**Re: Lot 9, 28 McPherson Street, Banksmeadow (SSD 9691)  
Response to Submissions**

Further to your request we are pleased to provide our response to the civil, stormwater and flooding items raised by Department of Planning, Infrastructure and Environment, Randwick City Council and Bayside City Council in their respective emails and associated information request letters.

STORMWATER OUTLET DISSIPATER WITH HEADWALL
SCALE 1:50

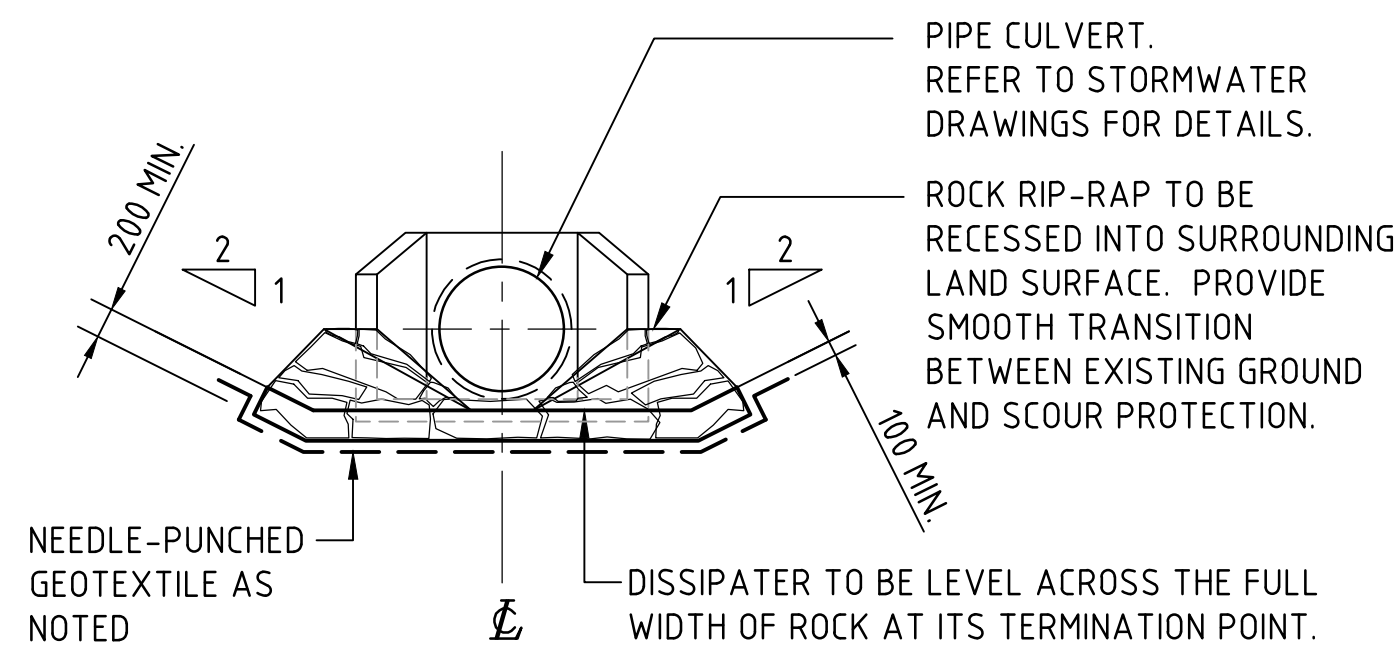
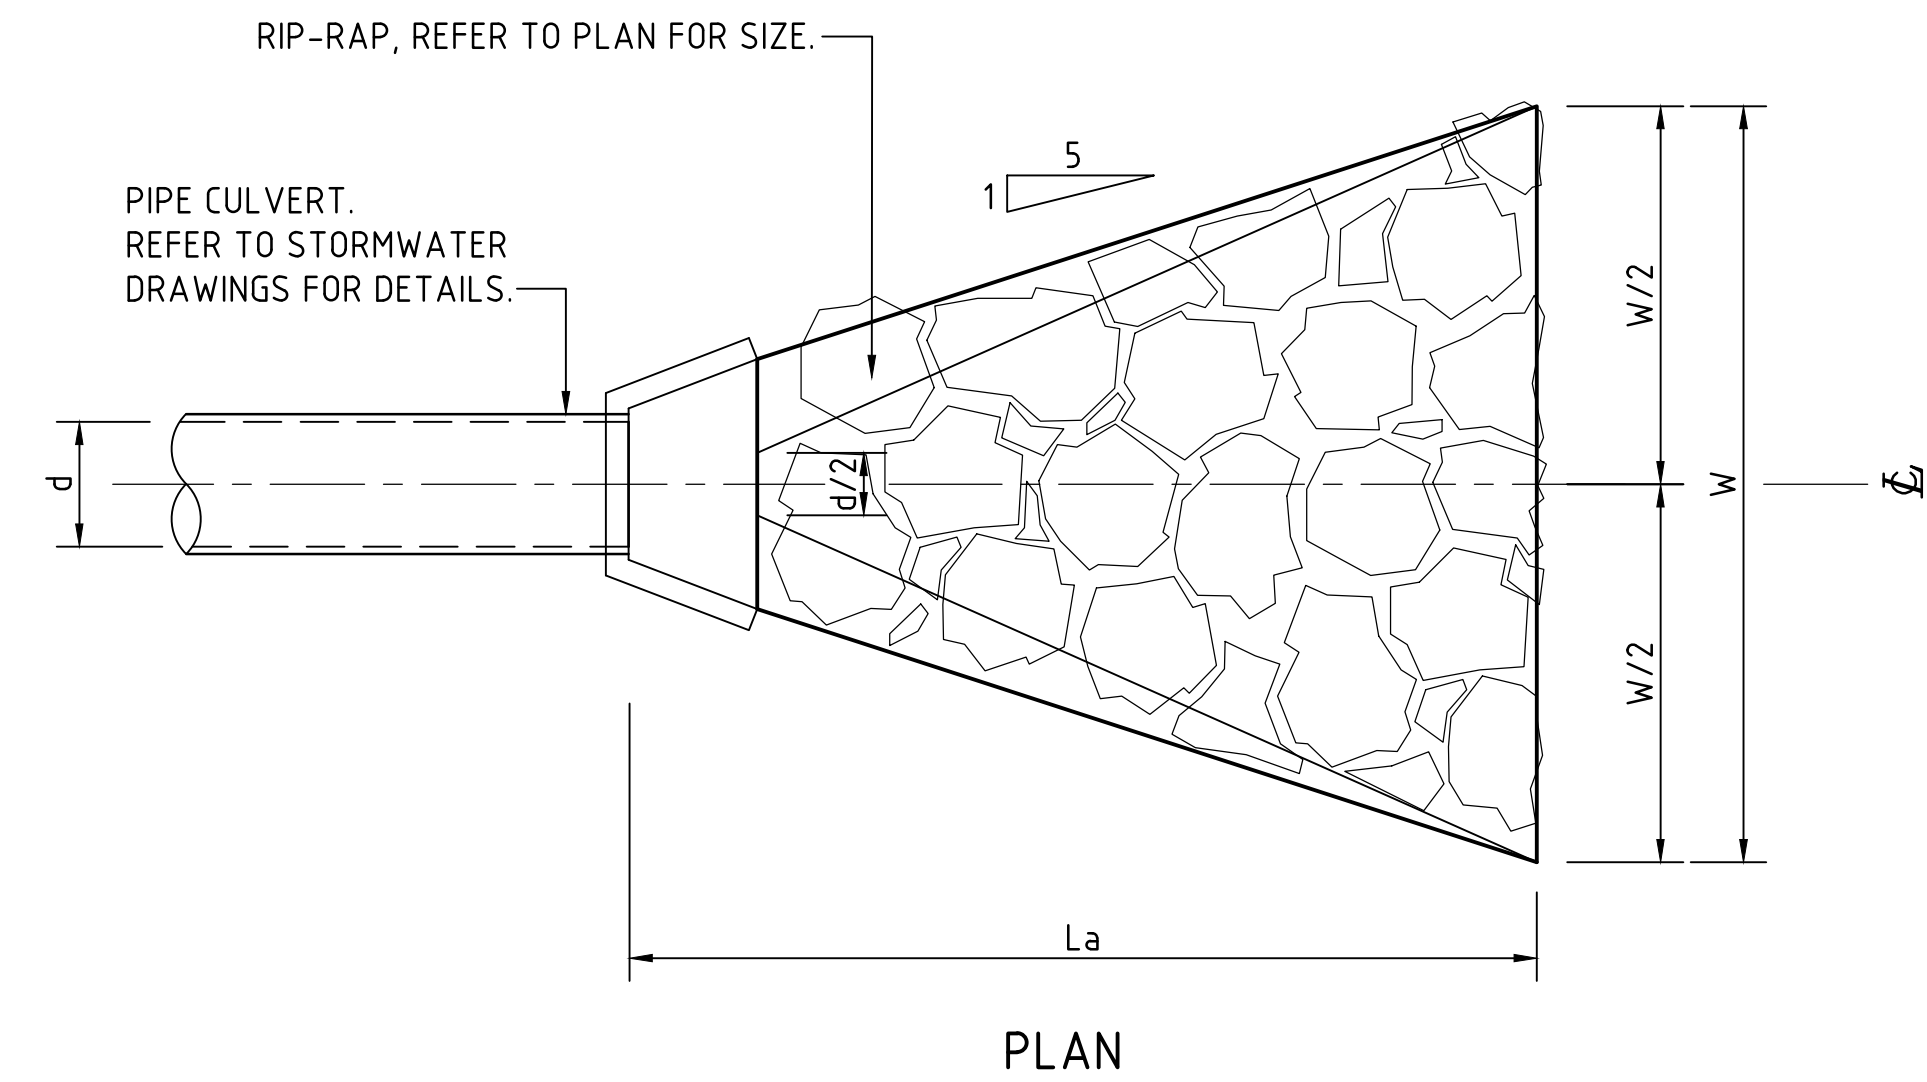
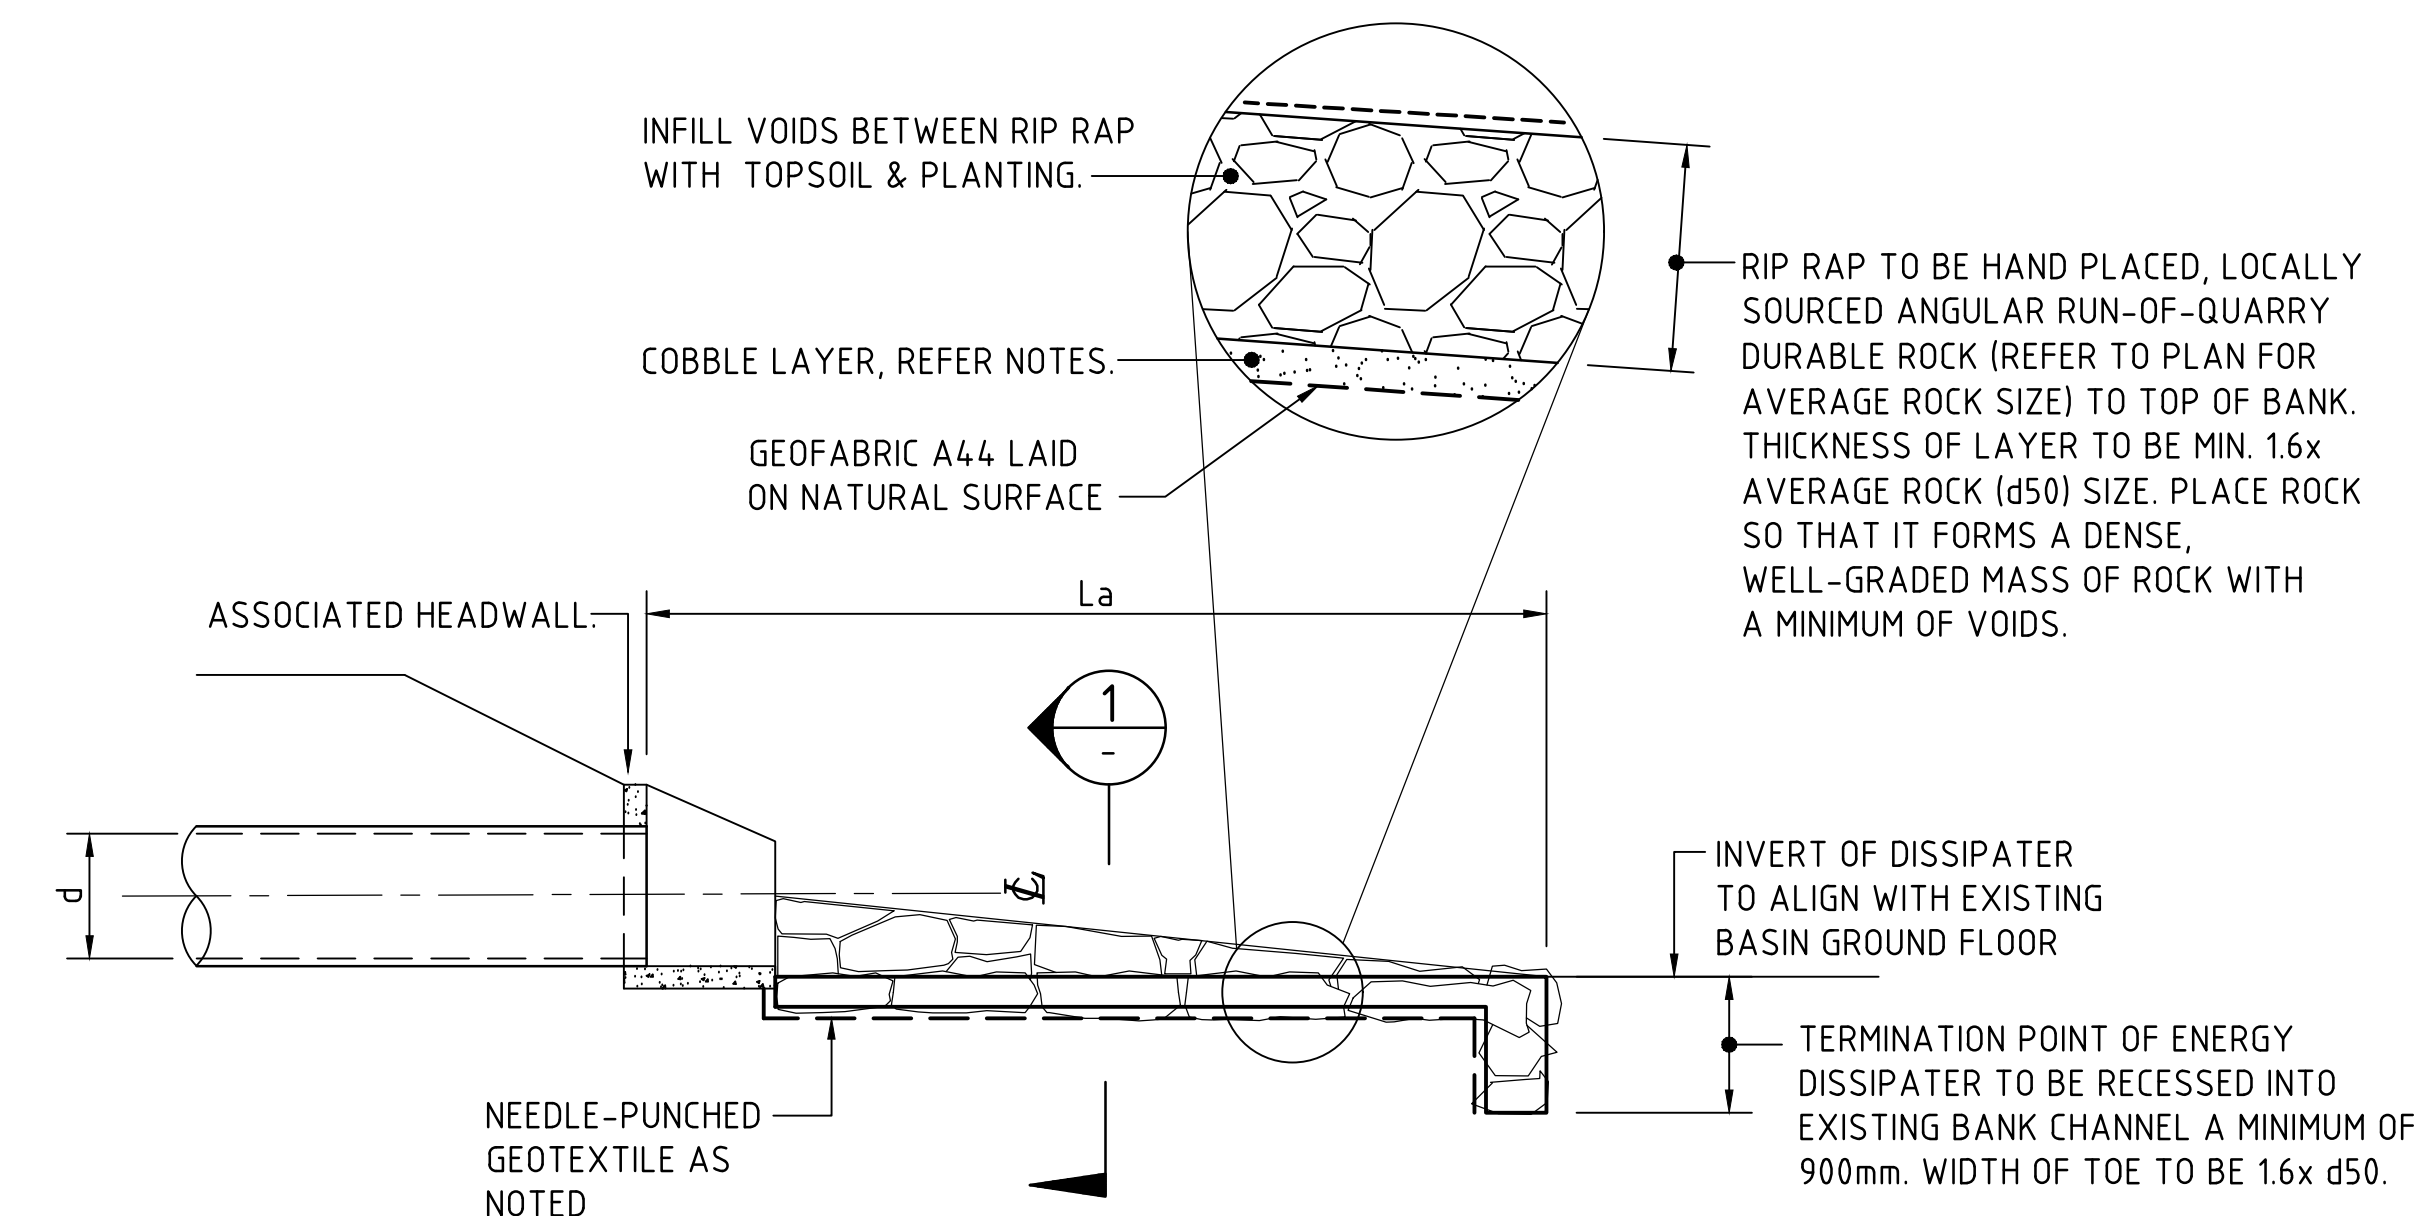
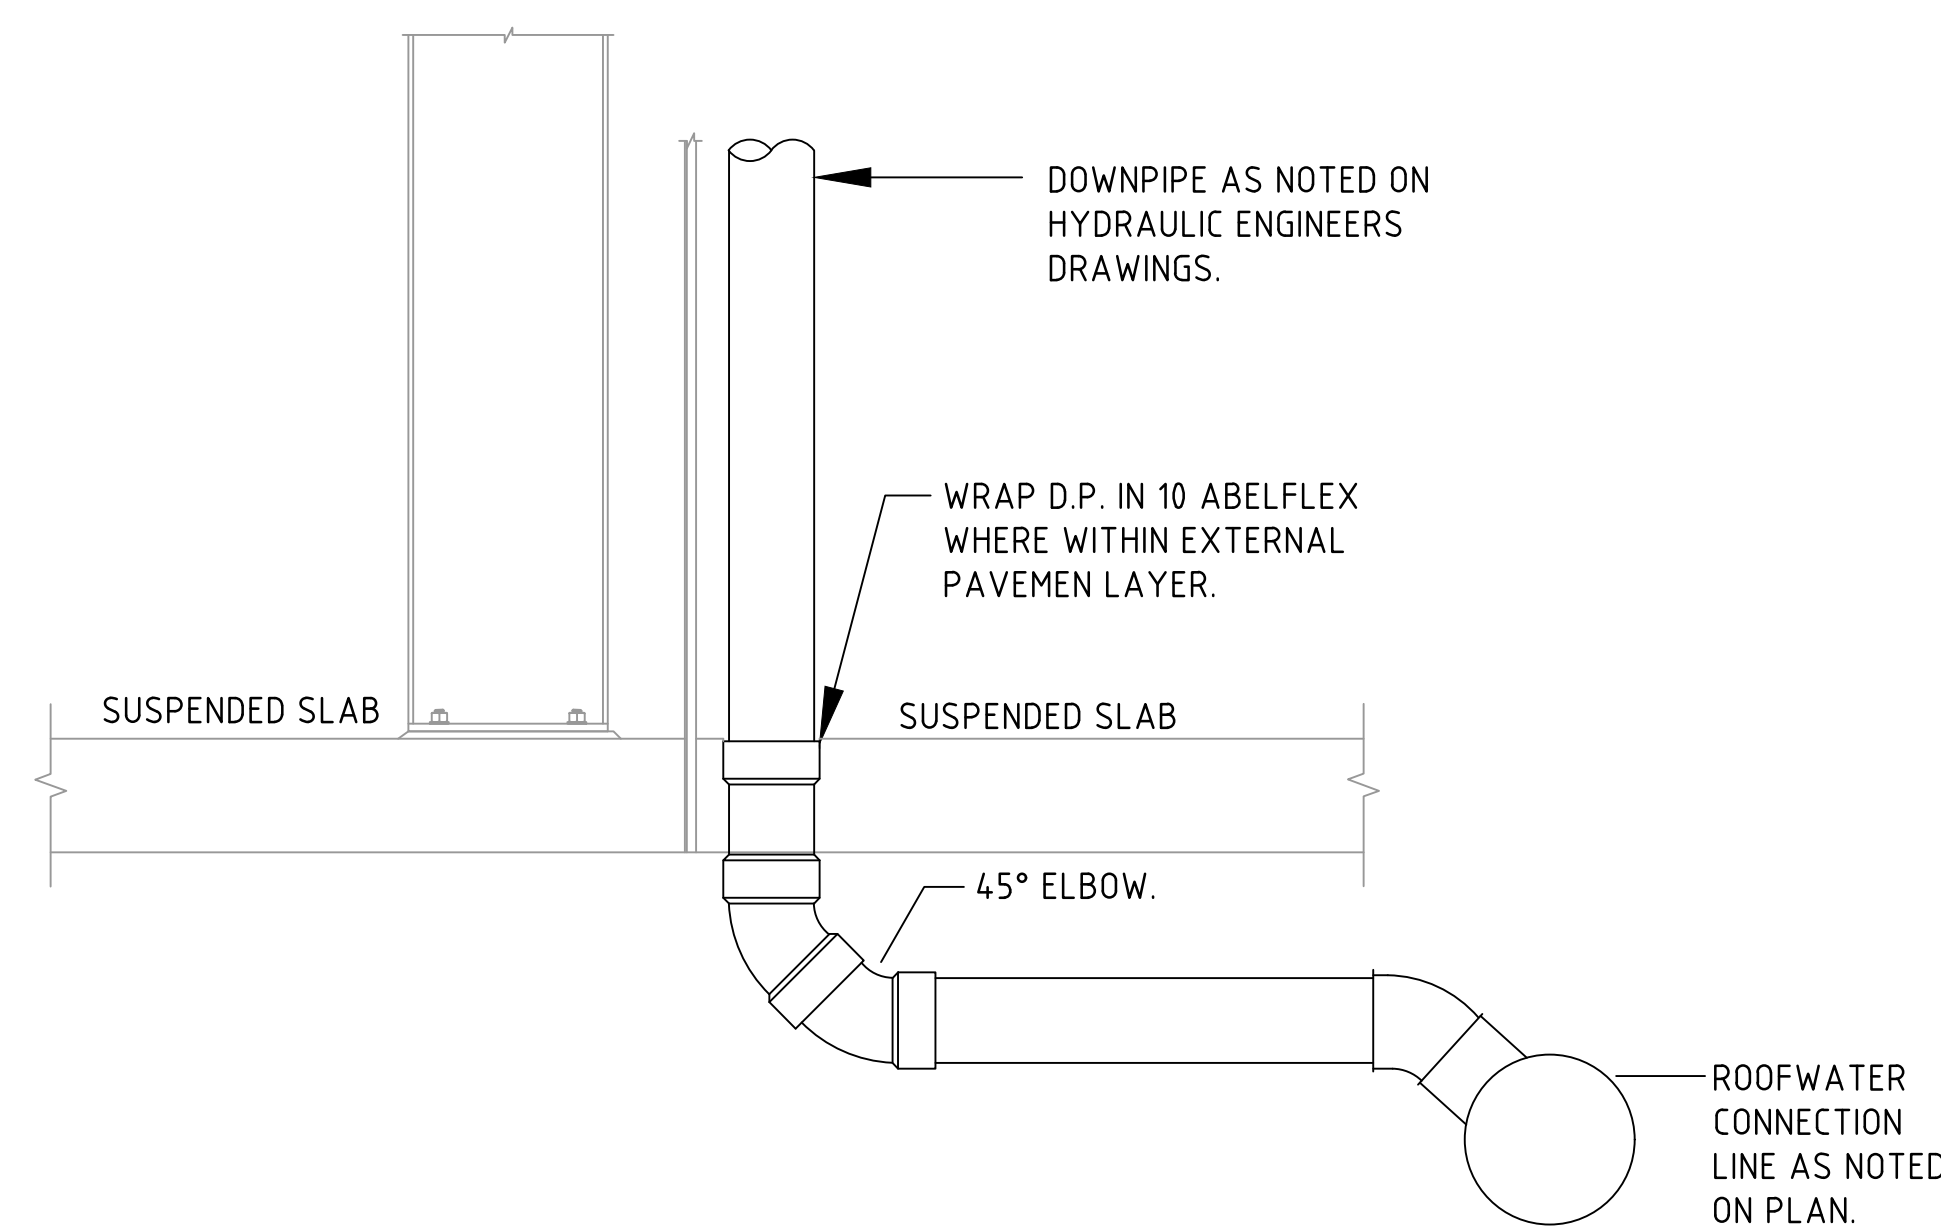
| <b>Stormwater Management</b> |                                                                                                                                                                                                                                                                                                                                                                                                                                                                                                                                                                                                                                                                                                                                                                                                                                                                                                                                                                             |
|------------------------------|-----------------------------------------------------------------------------------------------------------------------------------------------------------------------------------------------------------------------------------------------------------------------------------------------------------------------------------------------------------------------------------------------------------------------------------------------------------------------------------------------------------------------------------------------------------------------------------------------------------------------------------------------------------------------------------------------------------------------------------------------------------------------------------------------------------------------------------------------------------------------------------------------------------------------------------------------------------------------------|
| <b>Item 11)</b>              | <p><i>More details are needed for the ground floor slab drainage. An even distribution of drainage flow across the site into the storage basin below is required. Concentrated discharges are not supported from the ground floor slab into the basin.</i></p> <p><u>Response</u></p> <p>Proposed location of stormwater discharge from the ground floor slab drainage into the storage basin below are shown on drawing <b>Co9349.12-DA41</b> and <b>DA42</b>.</p> <p>Stormwater discharge is proposed to be distributed through the existing basin storage with the provision 11 discharge locations spaced regularly over the site.</p> <p>We also note that the recent development at 28A McPherson Street has been constructed with two concentrated piped discharge location into the existing storage basin. As part of this development it is proposed to provide energy dissipators per the NSW Office of Water Guidelines for discharge to natural waterways.</p> |
